Address: The Old Dewsbury Library, Wellington Road, Dewsbury, WF13 1HN

Application Ref: 2025/65/92140/E

Proposal: Listed Building Consent for alterations to former library to form 14 apartments with associated internal and external works (within a Conservation Area)

The Courtyard

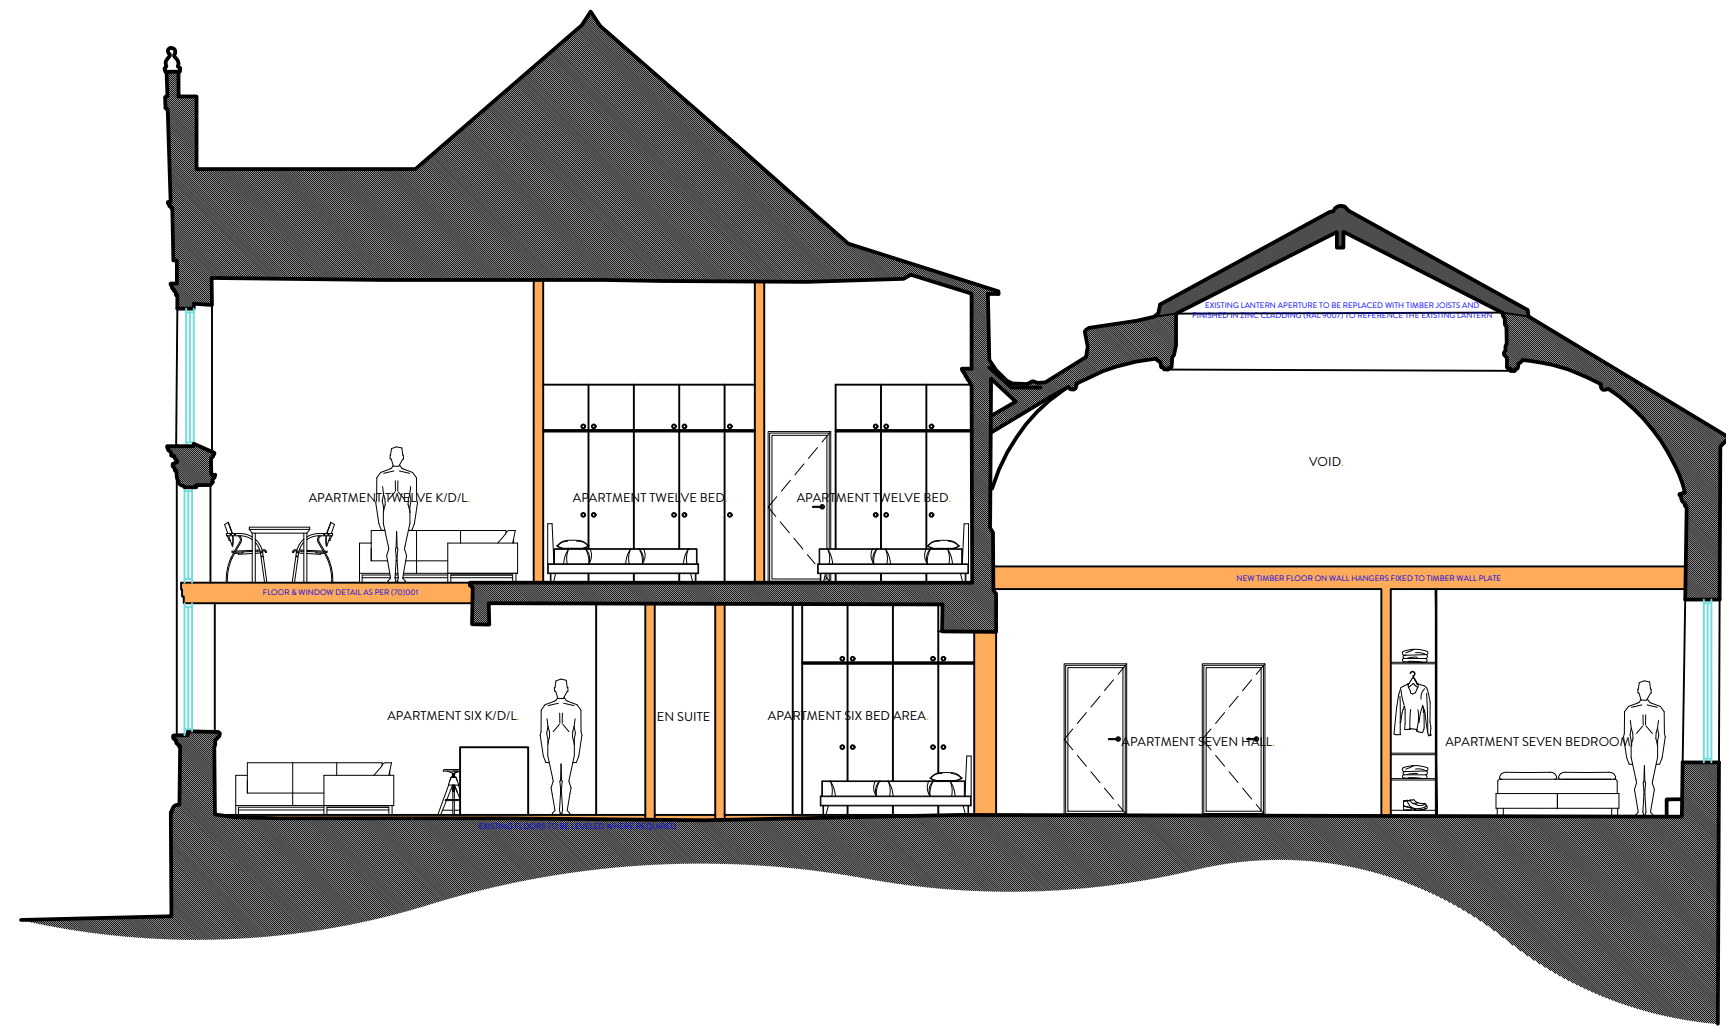
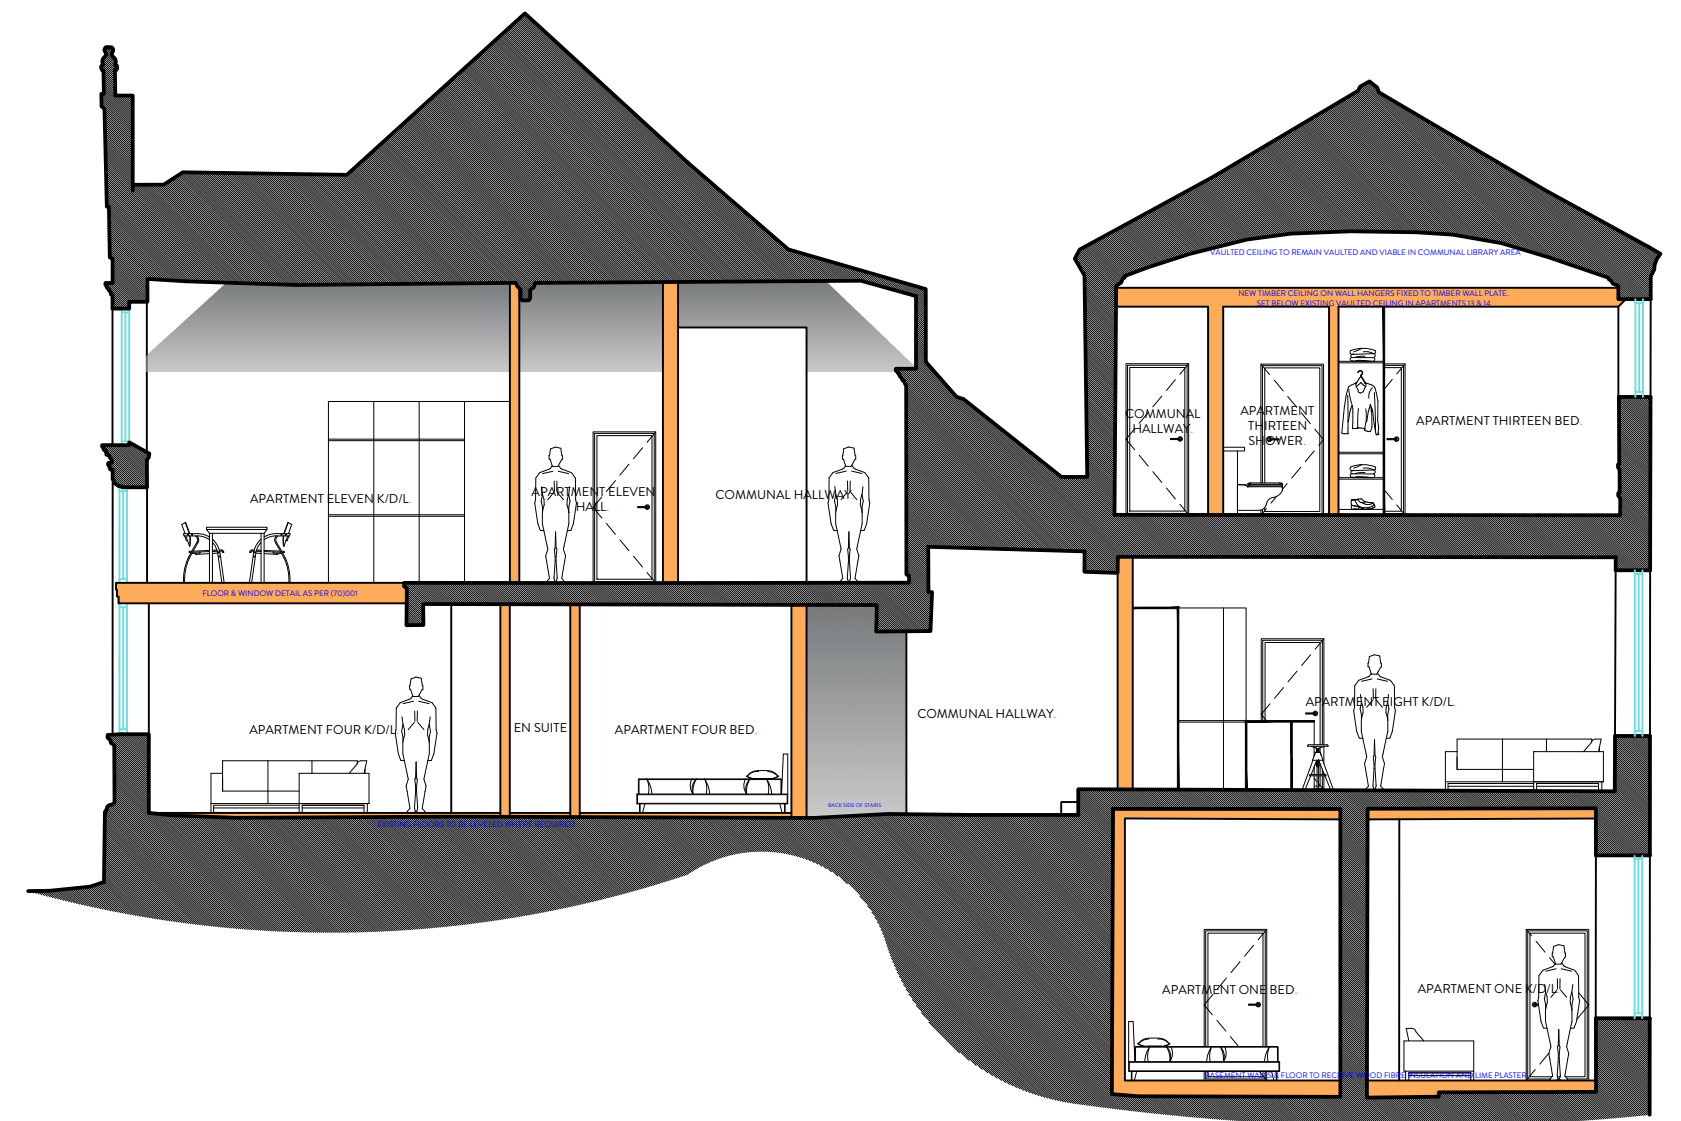
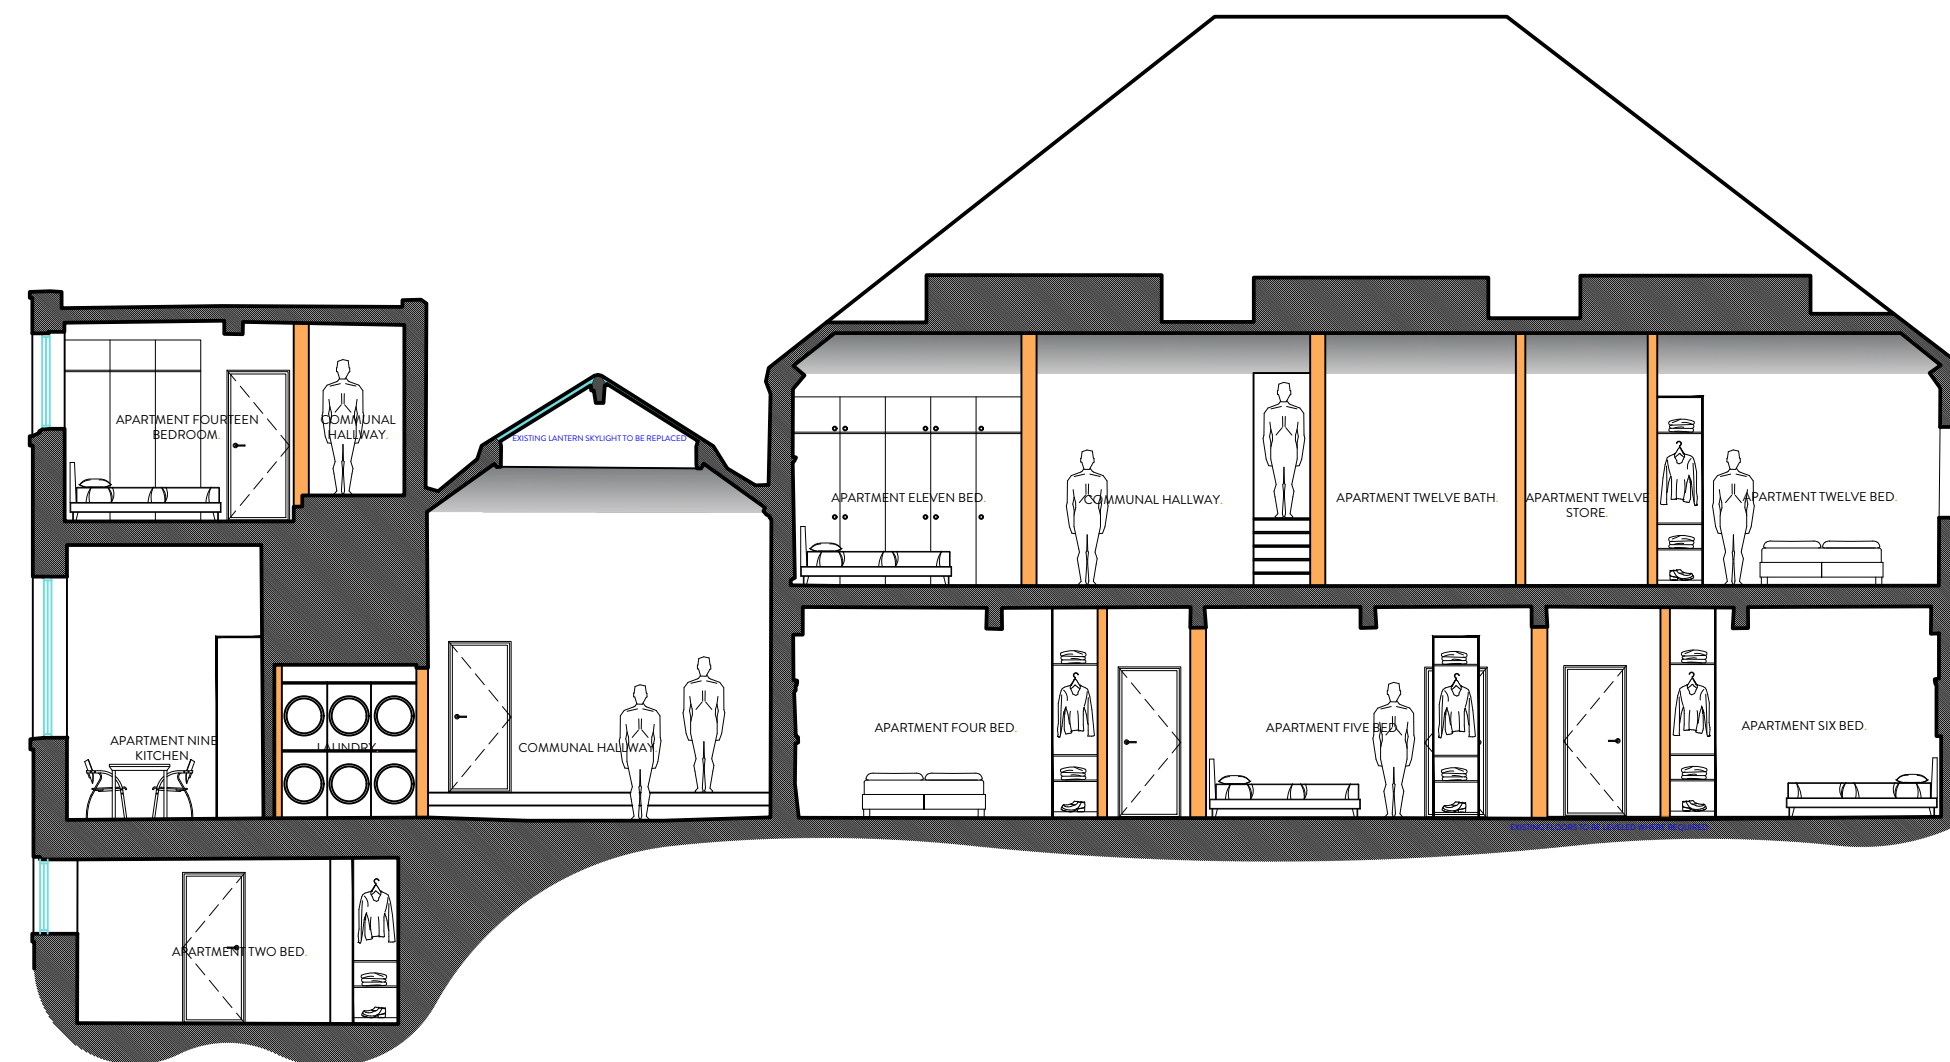
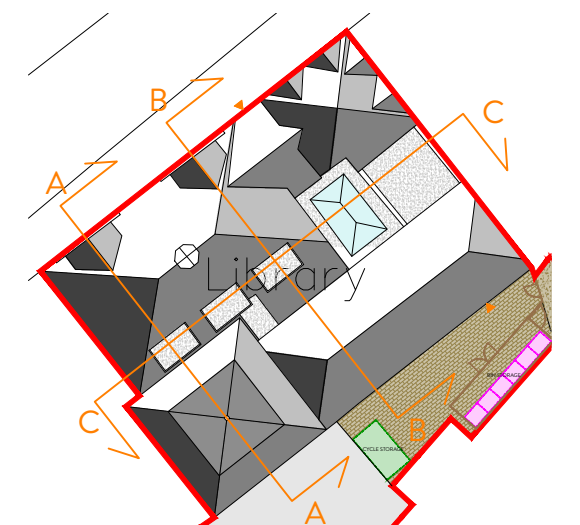
- Given the various changes to the floor levels and styles of ceiling (domed, barrel vaulted, etc.) section plans are essential to show the impact of the alterations.
- While the horizontal subdivision of the front reading room is acceptable, and we note the floor plate meeting the new horizontal transom, the first-floor apartments need to be reordered and designed so that they do not intersect the top half of the arched windows at the mullions. This spoils the integrity of these feature windows both internally and externally. The apartment partitions should fit the existing ceiling trusses.
- It is assumed the wall tiling and dado panels will be retained, restored and refitted. Likewise, the front northern rooms with the fireplace. This needs to be
